DELEGATED DECISION TO DETERMINE PLANNING APPLICATIONS TO CARRY OUT DEVELOPMENT WITHOUT COMPLIANCE WITH PLANNING CONDITIONS PREVIOUSLY ATTACHED

Reference No:	2026/70/91609/E
Site Address:	land at, Westfield Farm, Barnsley Road, Flockton, Huddersfield, WF4 4DW
Description:	Variation of condition 2 (plans) on previous permission 2019/92238 for demolition of existing buildings, renovation of farmhouse and erection of 4no dwellings including garages and formation of new access
Recommending Officer:	Nicole Helliwell

Officer Report

LOWER GROUND FLOOR PLAN

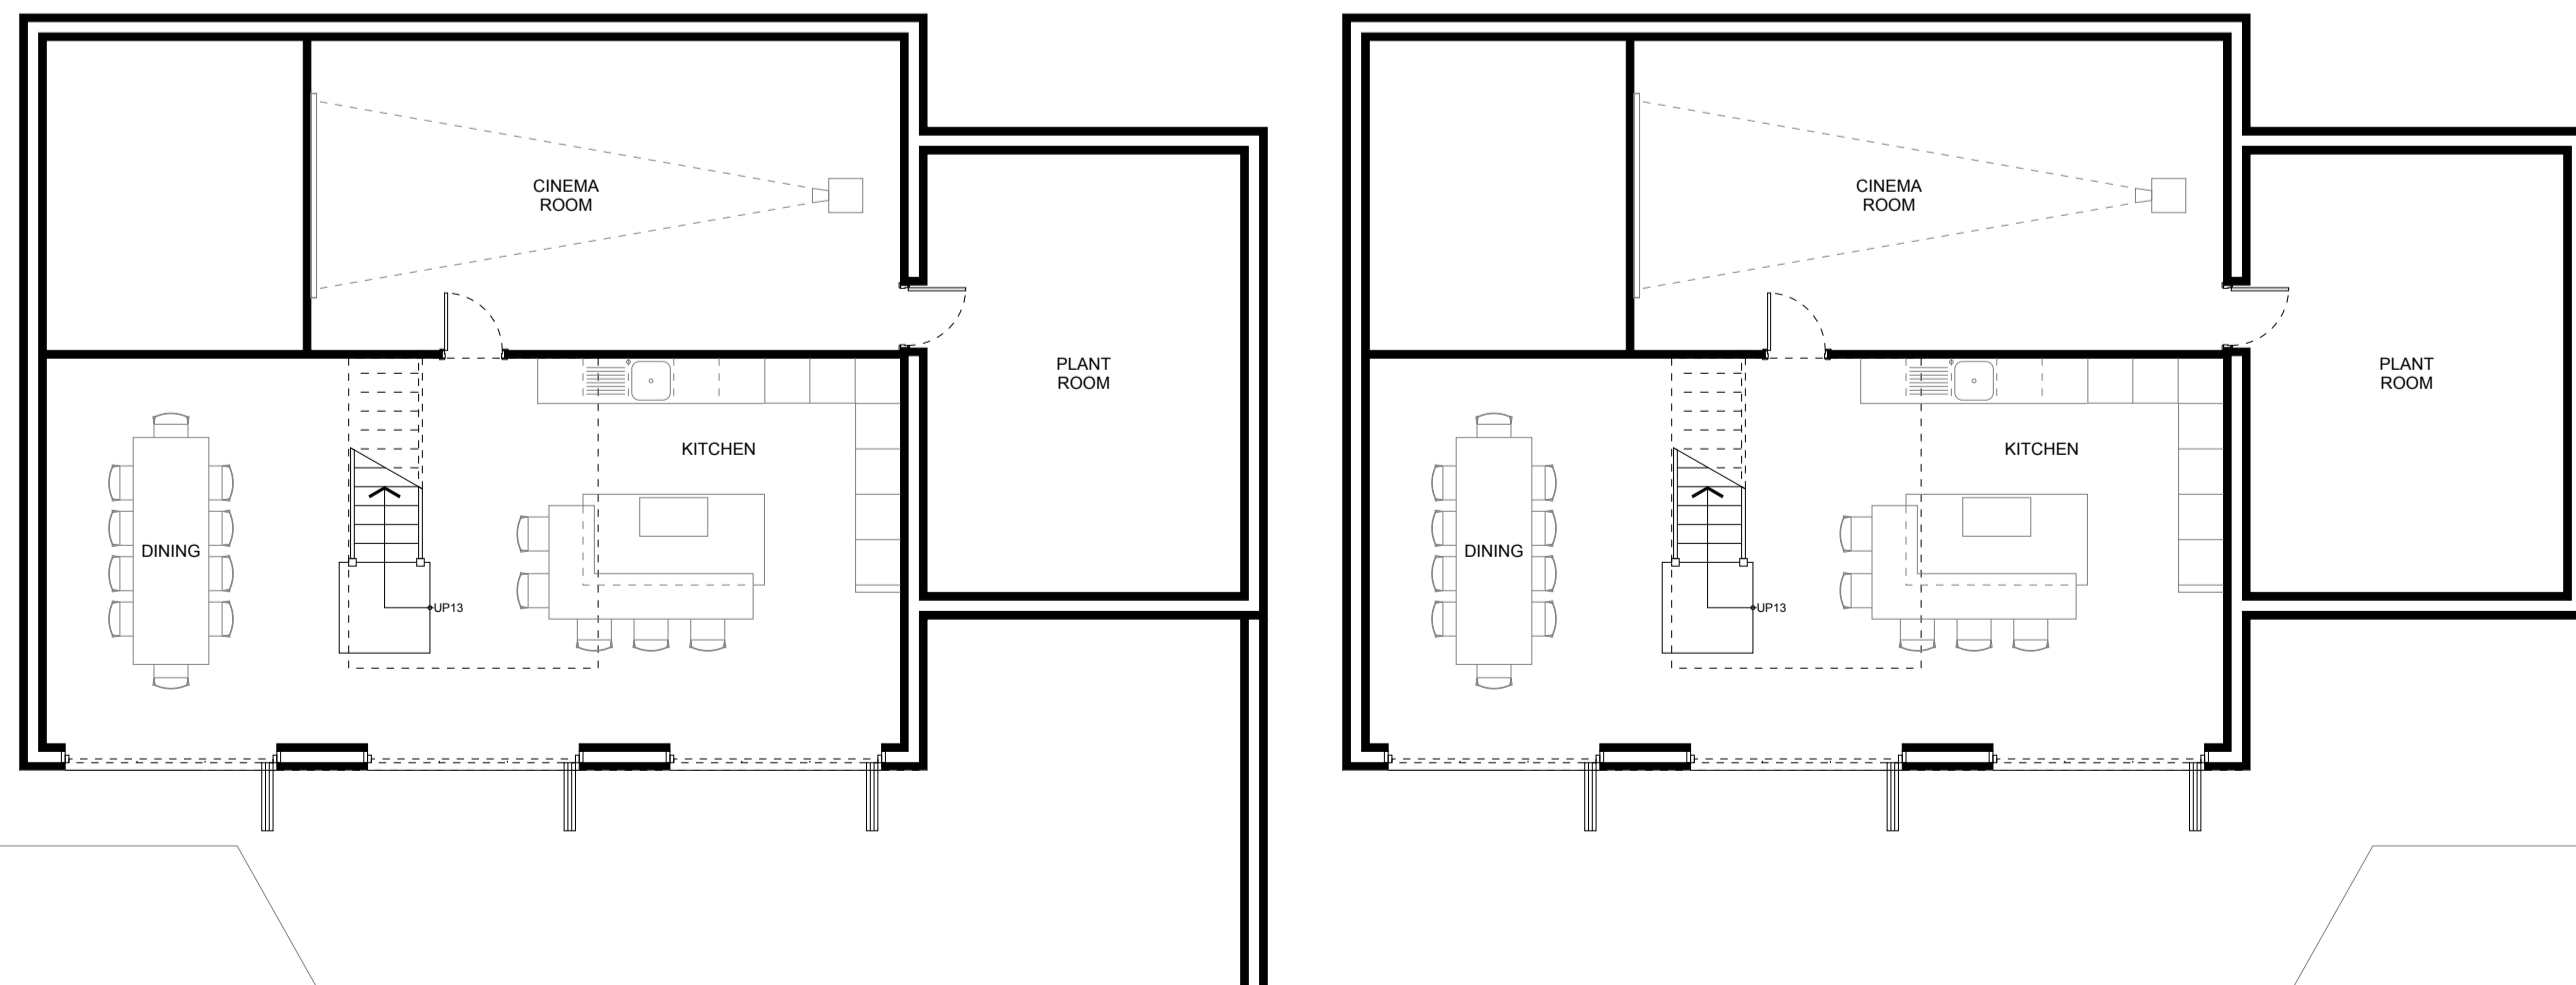
The submitted plans confirm that external alterations are proposed to create two detached split level properties. Units 4 and 5 would retain their traditional appearance from the northern elevation and would have a more contemporary appearance to the south. Whilst the overall scale and design of the dwellings would be altered as part of the variation, the resultant appearance is considered acceptable given that the dwellings would have limited visibility from public vantage points.

The dormer extensions would be located within the front and rear roof planes and would be of a traditional pitched roof design. Although no details have been provided regarding the material palette, a condition has been added requiring the dormers to be faced in materials to match the roof of the approved dwellings. Although the dormers would not be set back from the eaves, they would be sited below the ridge line and would not dominate the front and rear roof planes. The dormer windows would also be of an appropriate size and design and would generally align with the existing fenestration. Whilst it is noted that the area is generally devoid of dormer extensions, in this instance, the dormers are considered acceptable given the lack of uniformity within the street scene and that they would have limited visibility from public vantage points. Therefore, the proposed development would be acceptable from a visual amenity perspective.

The proposed canopies would extend approximately 1m from the northern elevations of Units 4 and 5 and would have an overall height of approximately 3.5m. Whilst it is acknowledged that front canopies are not a common feature within the street scene, it is noted that the structures would have a modest scale and would not appear overly prominent from public vantage points. Therefore, it is considered that the proposed amendment would be acceptable in terms of visual amenity.

Unit 1 and 2 are residential properties approved to the north of the application site. The submitted plans confirm that Unit 1 and 2 would occupy a position approx. 17m from the front elevation of Units 4 and 4. Although the separation distance would fall short of the 21m recommended within the Kirklees Housebuilders Design Guide SPD, it is taken into consideration that the approved relationship already falls short of this distance (2019/92238). Therefore, given that precedence has already been established within the street scene, the amendments are not considered to have a greater impact on the neighbouring occupants than the originally approved scheme.

Whilst no amendments are proposed to the access of the approved scheme, it is noted that the integral garages would be reduced in size as part of the application. However, the submitted plans demonstrate that off road parking would be retained at both units for three vehicles which would be an acceptable provision for a four bedroomed dwellinghouse. Therefore, the impact on highway safety is still considered acceptable and the proposal would comply with Policies LP21 and LP22 of the Kirklees Local Plan, Principle 12 of the Kirklees Housebuilders Design Guide SPD, advice contained within the Kirklees Highways Design Guide SPD and Chapter 15 of the NPPF.

16. Notwithstanding the submitted plans and information, the front and rear dormer extensions hereby approved shall be constructed in materials to match the roofs of the approved dwellings and retained thereafter.
